From: Daun Johnson on behalf of Planning.Responses
Sent: 05 July 2013 15:29
To: Planning Scanning; Amanda Scholes
Subject: FW: Planning Consultation on: FP/100/13/

From: Graham Evans
Sent: 05 July 2013 15:14
To: Planning.Responses
Cc: David Monk
Subject: FW: Planning Consultation on: FP/100/13/

NOTIFICATION FROM ARUN DISTRICT COUNCIL
Town & Country Planning Act 1990 (as amended)
Town and Country Planning (Development Management Procedure) (England) Order 2010 (as amended)
Planning Permission
APPLICATION **FP/100/13/**
NO:

Grid Reference: 495540 101210
Description of Application for Variation of Condition 40 imposed under
Works: planning consent FP/92/04 - relating to operating hours.

Project: Bognor Relief Road Viaduct	Description: Site Location and Nearest Residential Properties		 24Acoustics
DWG No: Figure 1	Scale: N.T.S.	Rev: A	
Date: March 2013	Drawn By: RP	Job No: R1401

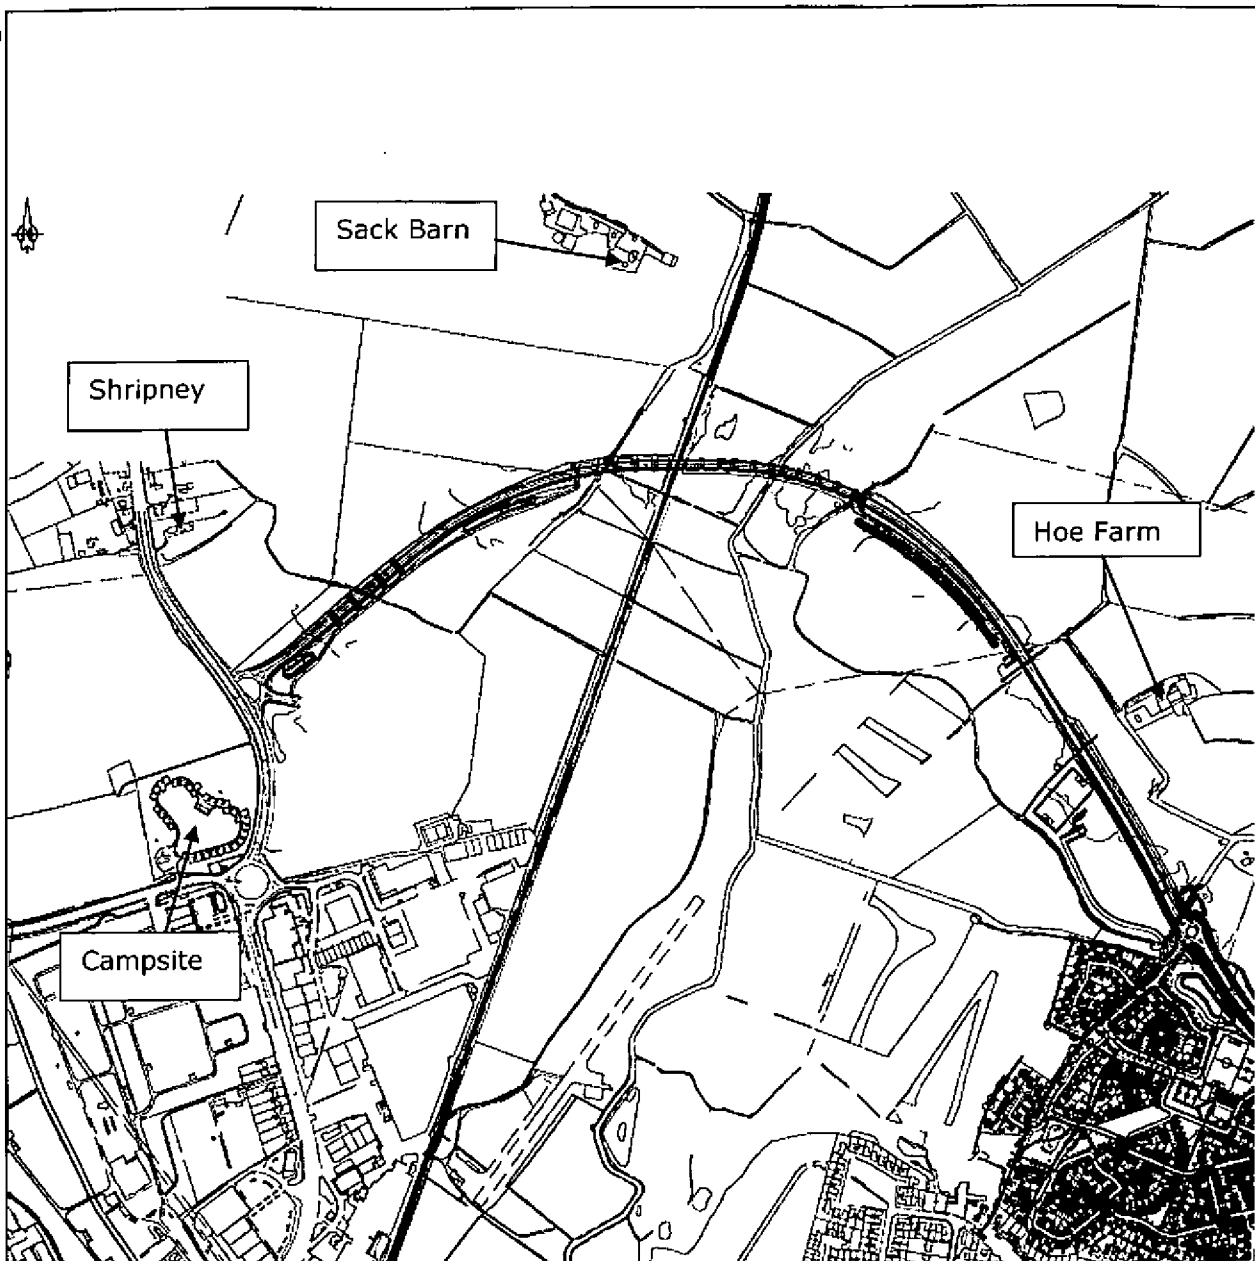
A limited number of residents (principally in the vicinity of Sack Barn) will potentially be significantly affected by night time works, the offer of temporary hotel accommodation to these residents during the weekend possessions should be considered. Further noise assessment once works have commenced may inform this decision.
